Location of Construction: 30 Pitt St	Owner Name: Broche Gabrielle	Owner Address: 30 Pitt St	Phone: 828-1023
Business Name:	Contractor Name: allison carpentry	Contractor Address: 58 Osborne Avenue So. Portland	Phone: 2078381024
Lessee/Buyer's Name	Phone:	Permit Type: Additions - Multi Family	Zone: R-5

Past Use: 2 Family	Proposed Use: 2 Family	Permit Fee: \$429.00	Cost of Work: \$57,400.00	CEO District: 2
Proposed Project Description: 18 x 22 addition to 1 floor unit.		FIRE DEPT: <input type="checkbox"/> Approved <input type="checkbox"/> Denied	INSPECTION: Use Group: R-3 Type: SB BOCA 1999	
		Signature: <i>[Signature]</i>		Signature: <i>[Signature]</i>
PEDESTRIAN ACTIVITIES DISTRICT (P.A.D.)				
Action: <input type="checkbox"/> Approved <input type="checkbox"/> Approved w/Conditions <input type="checkbox"/> Denied				
Signature: _____ Date: _____

30 Pitt St - 5/31/02 - plot plan not scalable and no setbacks shown - no stairway shown - no open outside stairway allowed - shows a "future kitchen" which can not be done. Left voice mail with owner to resubmit info. 6/5/02 met with owner & she resubmitted plans showing

Plan of Future Kitchen

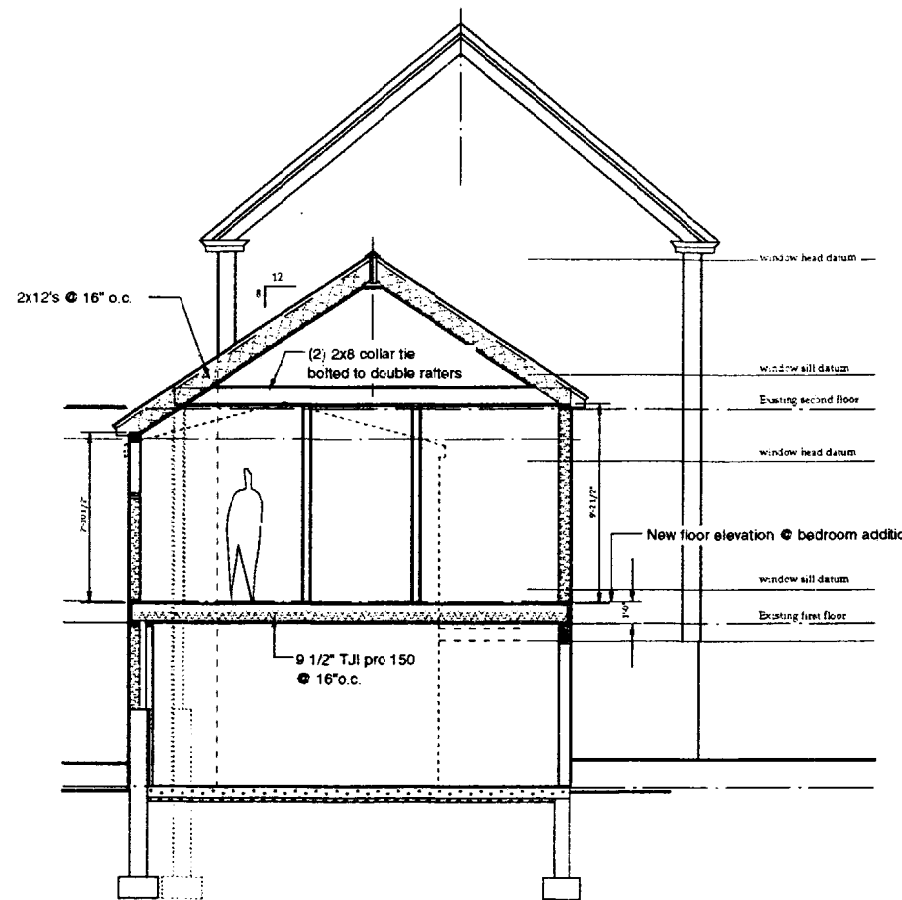
This is NOT an approval for an additional dwelling unit. You SHALL NOT add any additional kitchen equipment including, but not limited to items such as stoves, microwaves, refrigerators, or kitchen sinks, etc. Without special approvals. You may not wire up nor plumb up for any "future kitchen".
